From: [REDACTED]
Sent: 15 April 2026 15:36
To: Susan Haley
Subject: RE: A/33/26/HH - 29 Mill Road Avenue, Angmering
Attachments: P002 - Proposed Block Plan Rev 2.pdf

[REDACTED]
Subject: RE: A/33/26/HH - 29 Mill Road Avenue, Angmering

Drawing No.	Revision:	Suitability Description:
P002	P1	PLANNING
Drawn: MS	Checked: GF	Orig Paper Size: A3

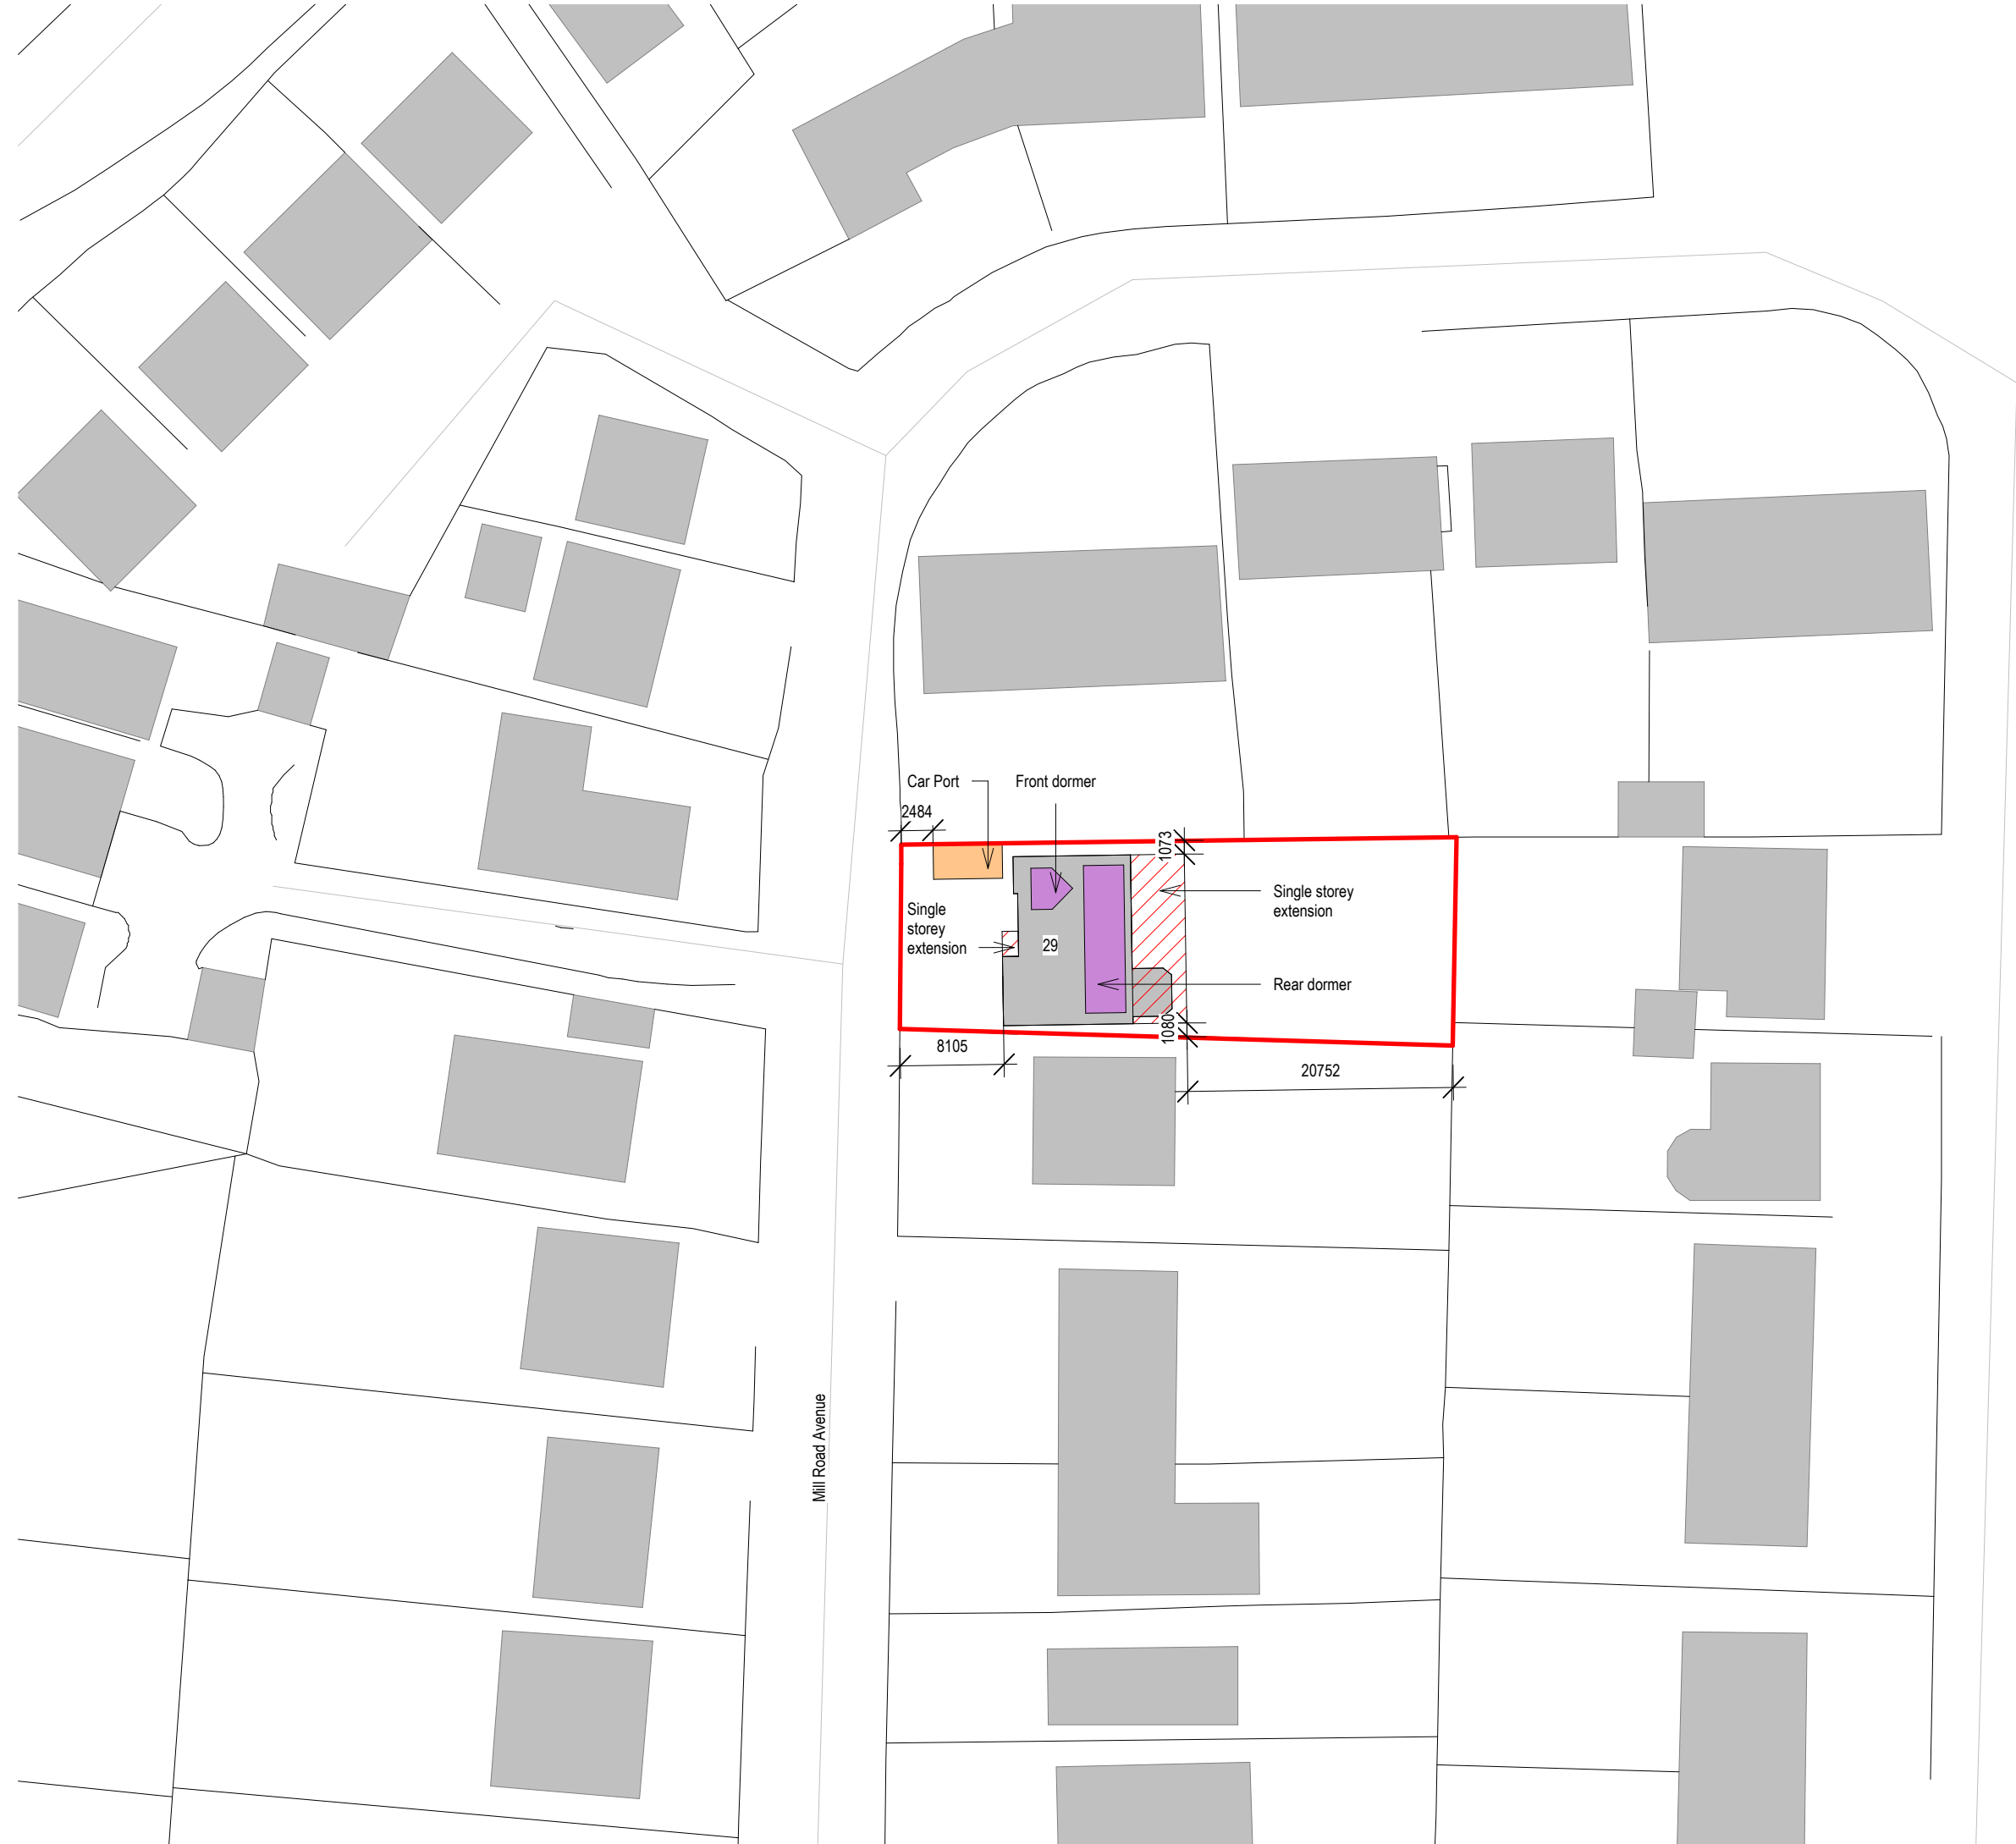
On further discussions with colleagues today, please can you confirm the exact materials proposed for the car port (timber or aluminium), and please amend the 'Proposed Block Plan P002' [REDACTED] and I will upload the amended plan against the application.

Many thanks, please see attached amended block plan.
Aluminium for the proposed car port please.
